Rezoning Transportation Analysis

Petition Number: 2021-154

From: Brandon Brezeale, PE

Date	Description
12-28-2021	First Review (KP)

Project and sheet information table. Includes Project Name (Price Lane Townhomes PHII), Petition Number (2021-XXX), Sheet Number (RZ-01), and a revision table with columns for REV., DATE, and DESCRIPTION.

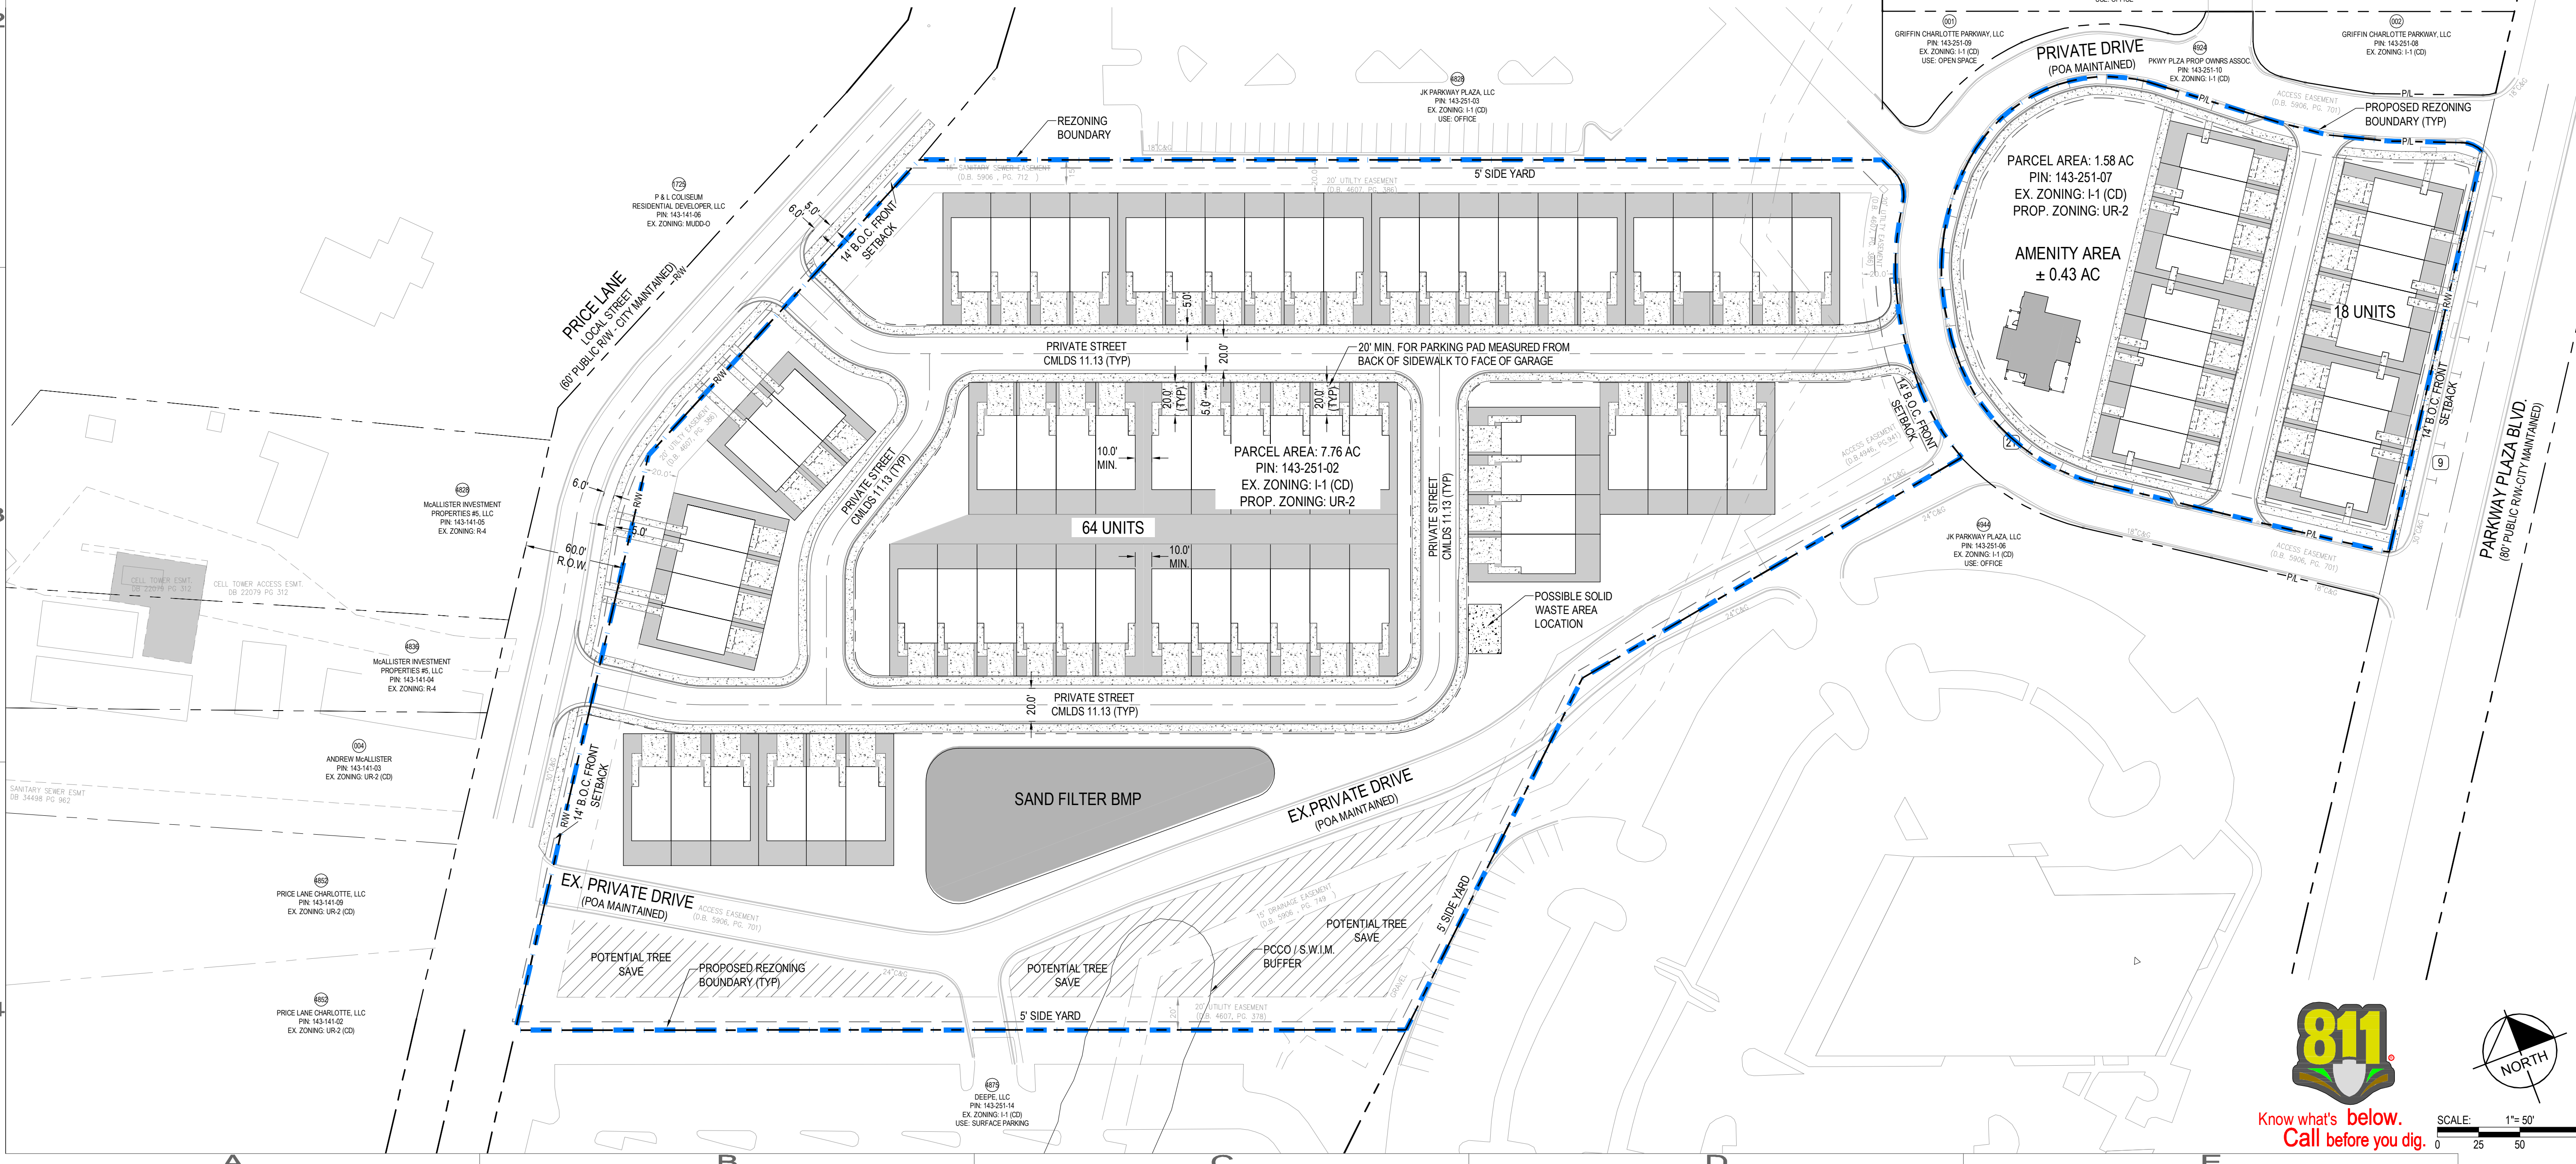
1. **Curb line:** The proposed zoning district has a setback measured from back of the existing or proposed future curb line.
 - a. **Price Lane:** Location of curb and gutter may remain in it's current location.
 - b. **Parkway Plaza Boulevard:** Location of curb and gutter may remain in it's current location.

Label and dimension the curb and gutter from the existing centerline to the back-of-curb for each road on the site plan.

3. Revise site plan and conditional note III.d to commit to construct an 8-foot planting strip and 6-foot sidewalk along the site's frontage of Price Lane and Parkway Plaza Boulevard. The site plan shall label and dimension both items from the back of curb and gutter and road centerline.

4. Revise the site plan and conditional notes to commit to provide recessed on-street parking, in accordance with CLDSM details 50.09C and 50.09D, along the site's frontage of Parkway Plaza Boulevard.

5. Revise the site plan by showing the missing 8 townhomes.

Please show the 8 units on the site plan

6. Revise the site plan to commit to provide four ADA curb ramps at the proposed private street intersection near the amenity area.

7. Revise the site plan by modifying the proposed internal private street network by removing the proposed southern driveway, on Price Lane, and providing an internal connection to the existing private street.
